WEST SUSSEX COUNTY COUNCIL CONSULTATION

TO:	Arun District Council FAO: Mr S Davis
FROM:	WSSC – Highways Authority
DATE:	24 July 2026
LOCATION:	Land At Freeman Close Walberton BN18 0AE
SUBJECT:	WA/46/26/PL Change of use of and conversion of existing buildings and land to form 25 no. dwellings (within existing footprints) with associated hard and soft landscaping, parking, car ports, play areas, and works. This application is a Departure from the Development Plan, also lies within the parish of Barnham and is in CIL Zone 3 and is CIL Liable as new dwellings.
DATE OF SITE VISIT:	n/a
RECOMMENDATION:	No Objection

Refuse Vehicle Swept Path Tracking

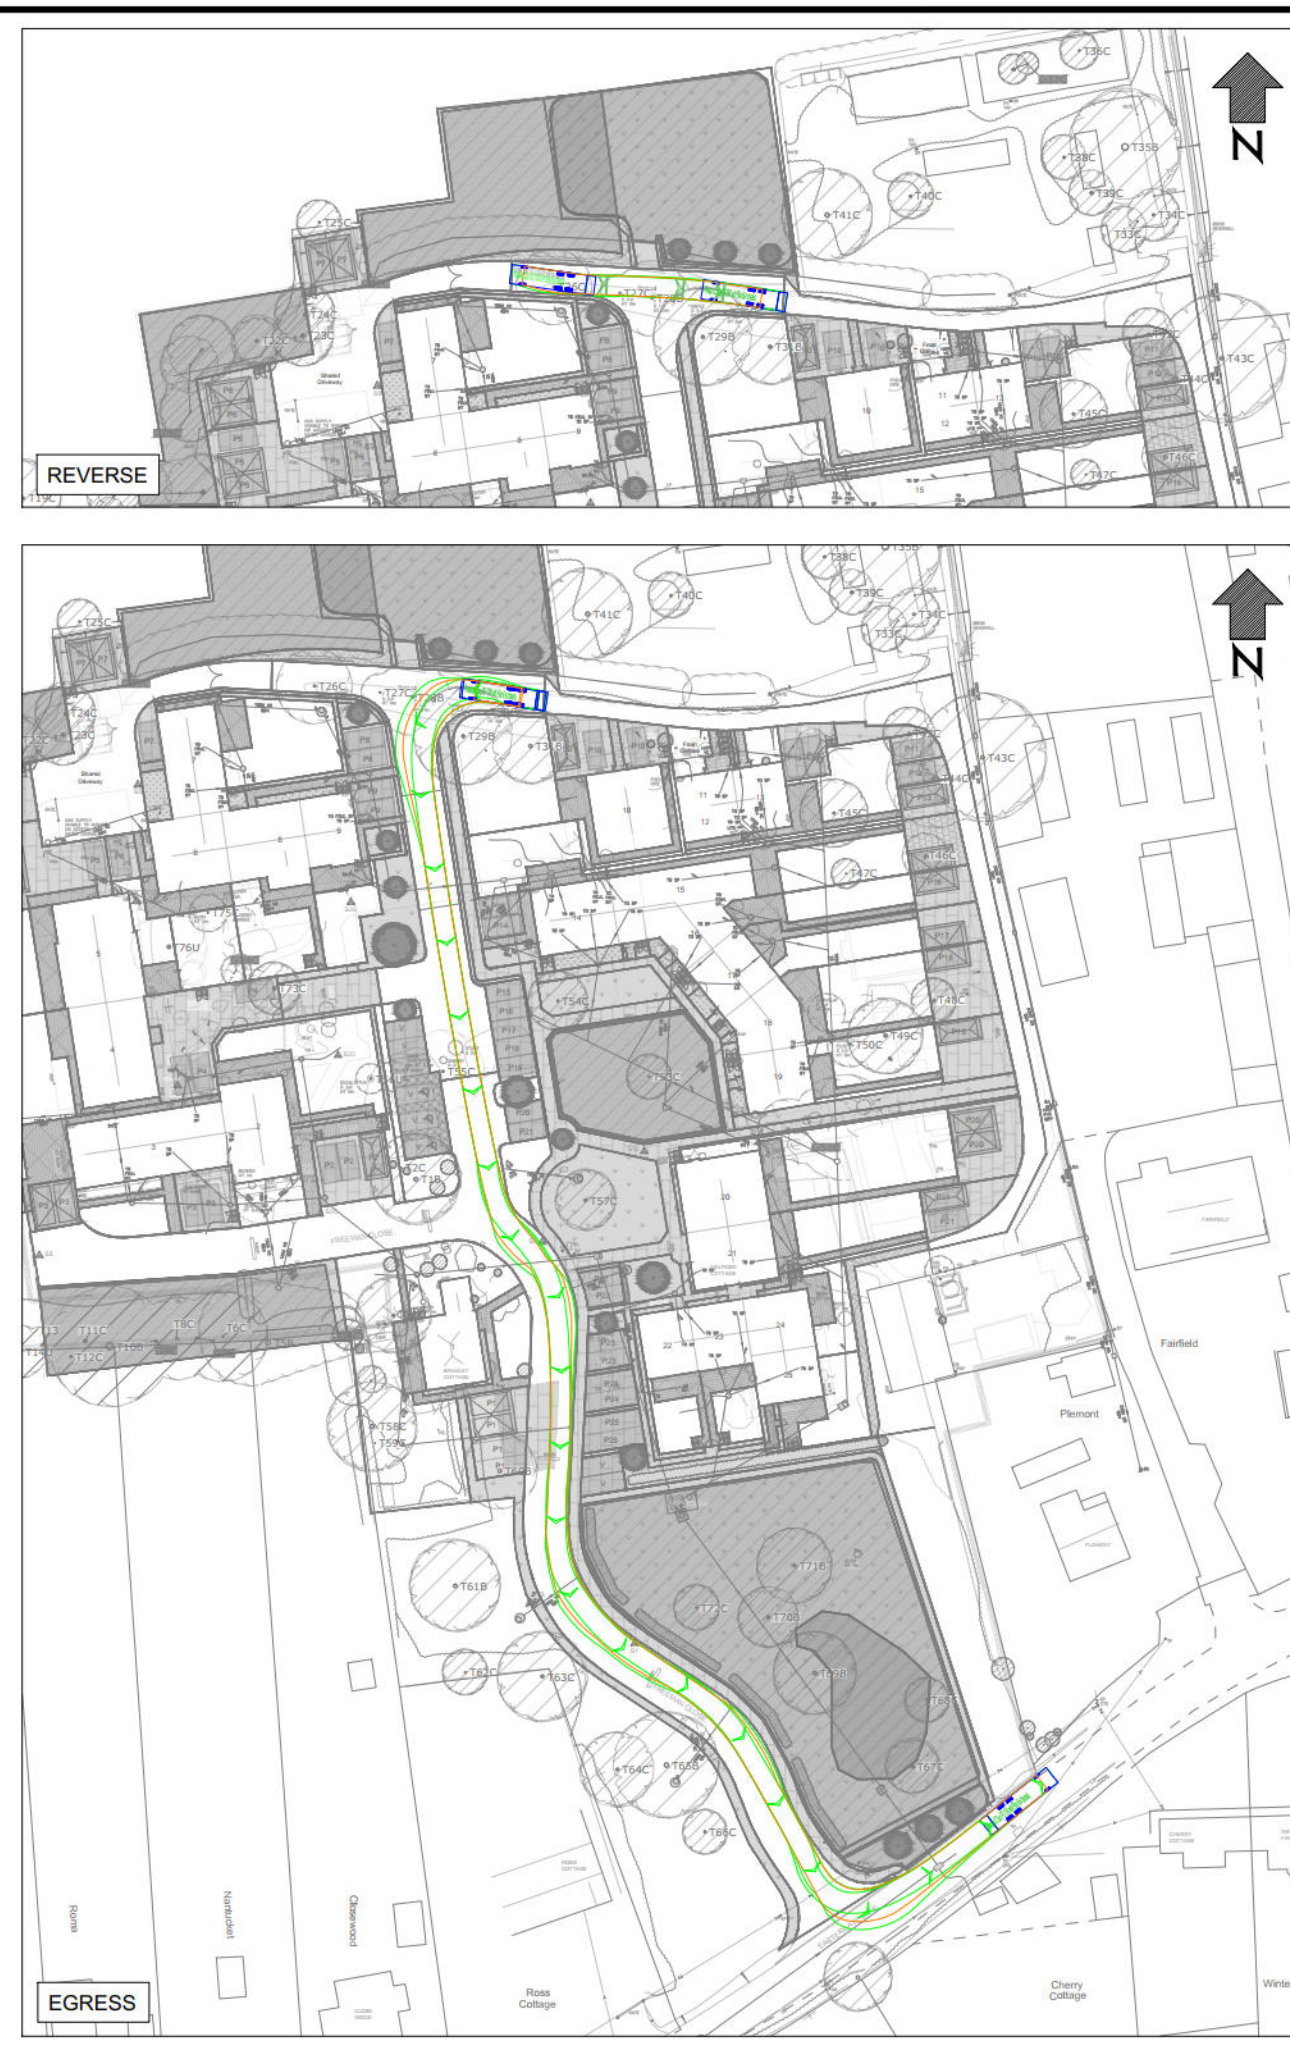
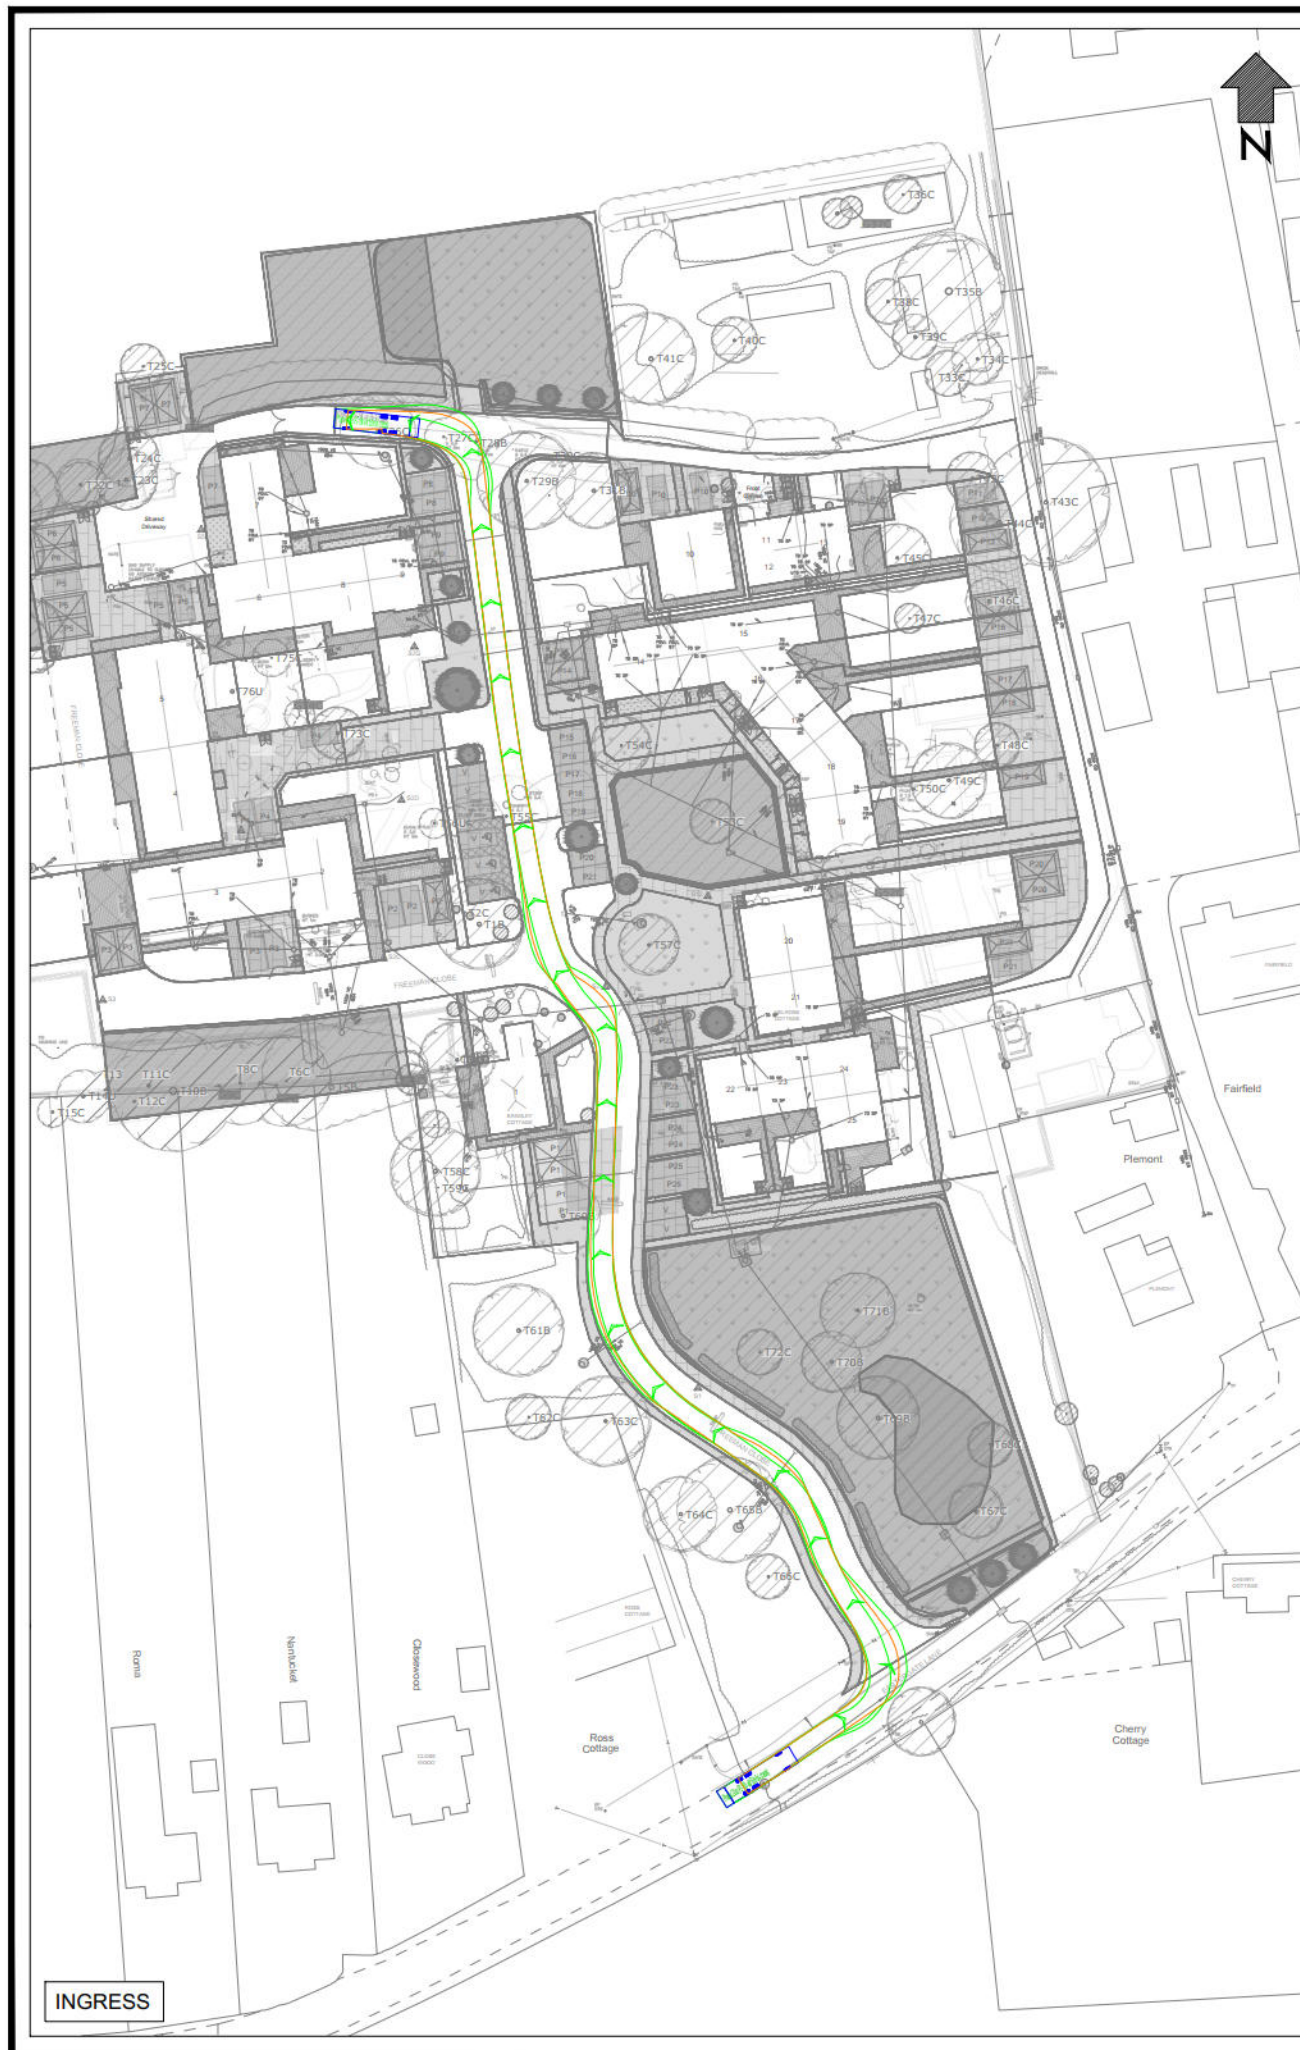
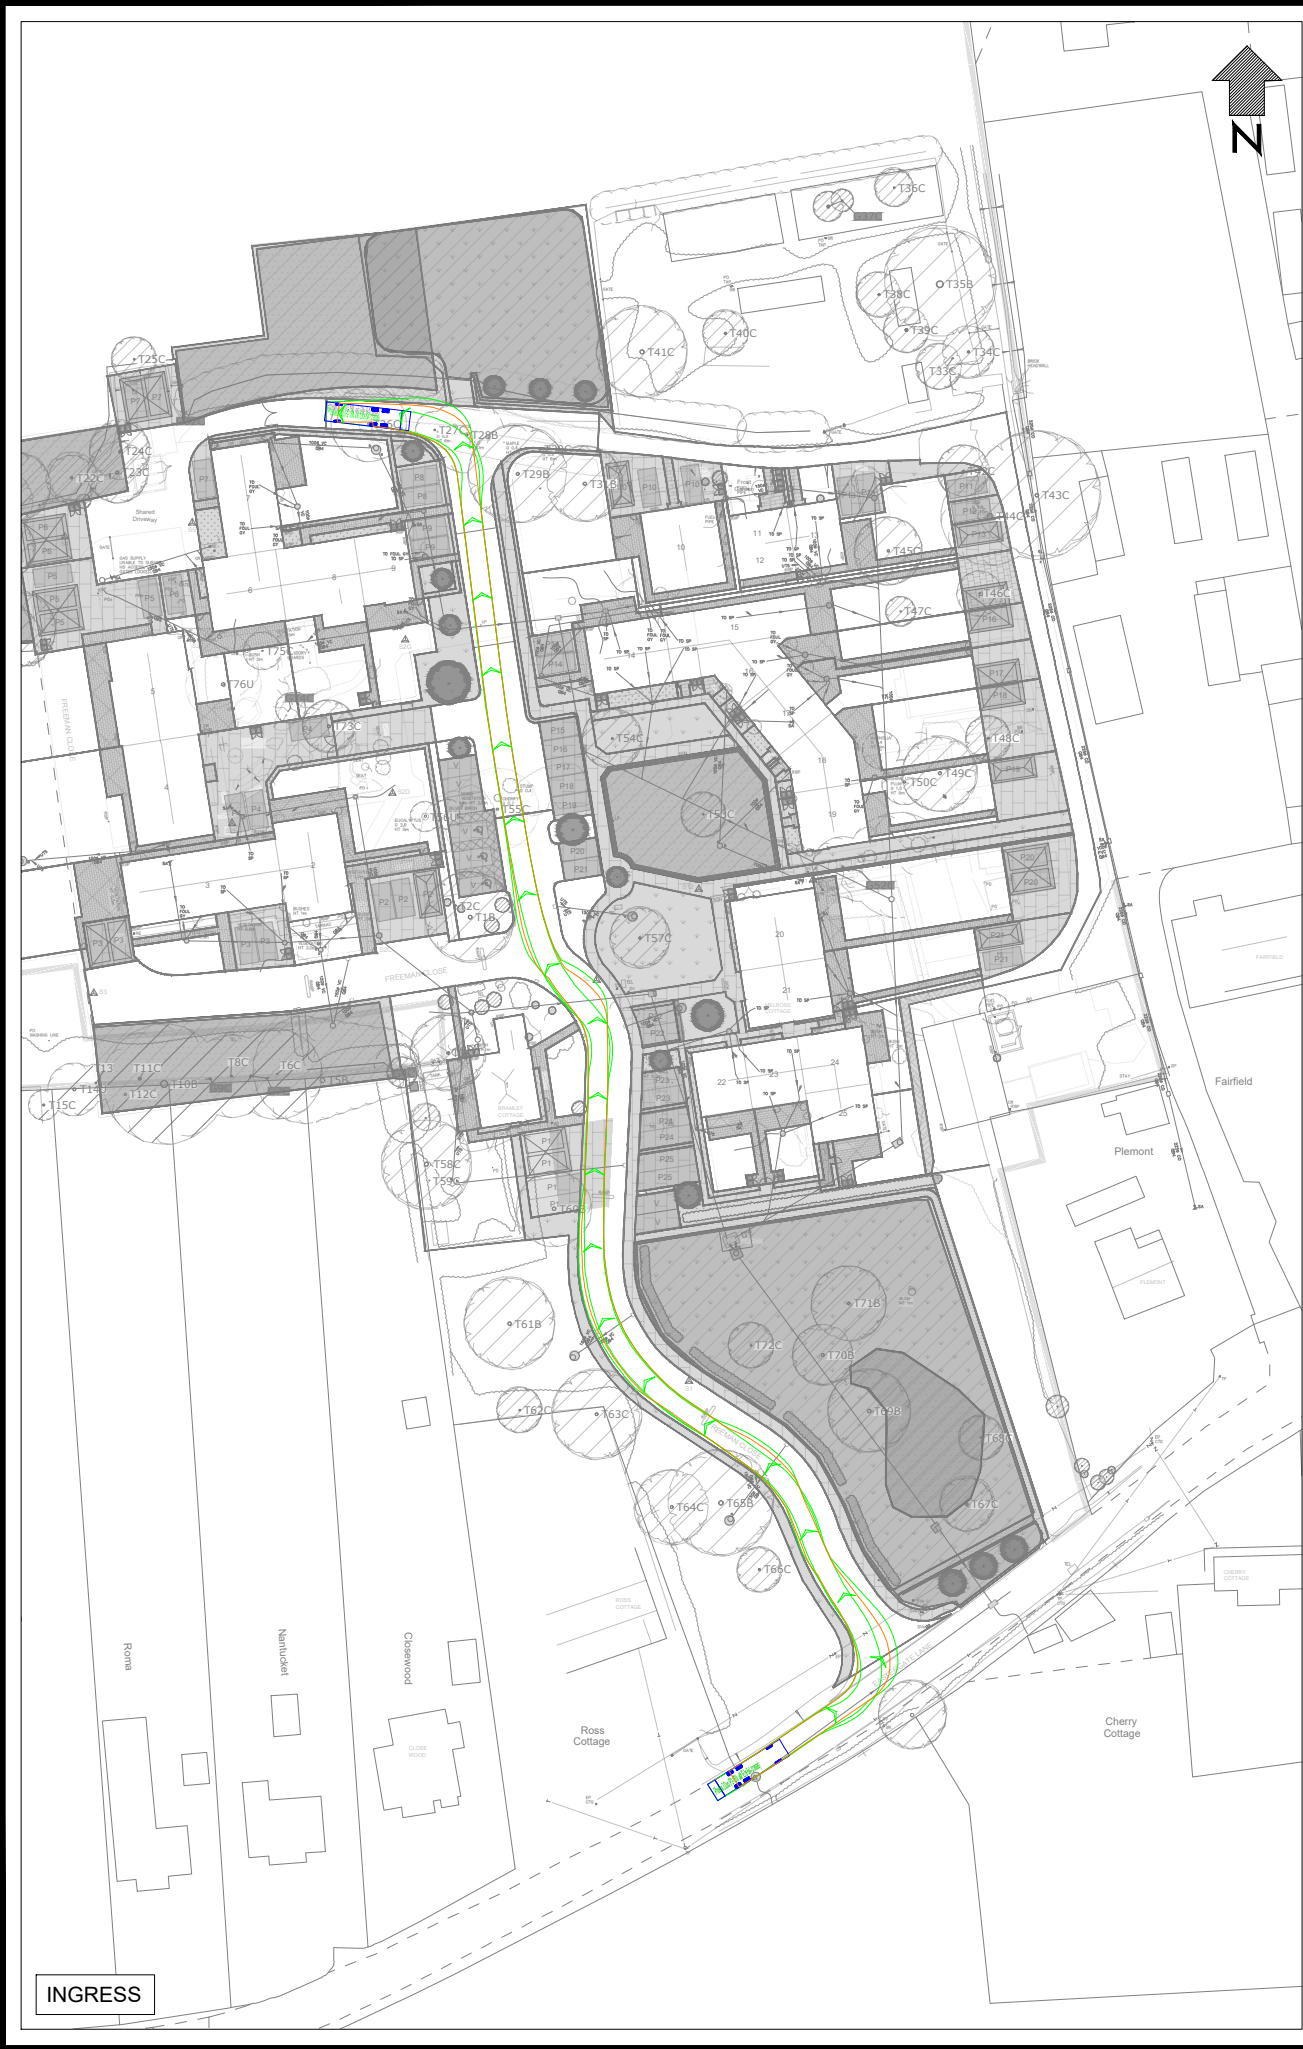
SPA has been shown for a refuse vehicle. This can enter turn and exit in forward gear. As shown on the access and tracking drawing NJC-003. It is noticed the surfacing changes at the turning head. This may give the impression that this is a shared surface area, but generally block paving is used for low turning vehicle movement areas.

WSCC would advise the main spine and tuning heads at the end of the road would lend themselves to tarmac, and the roads leading off the spine are more suited to block paving as they are serving less dwellings.
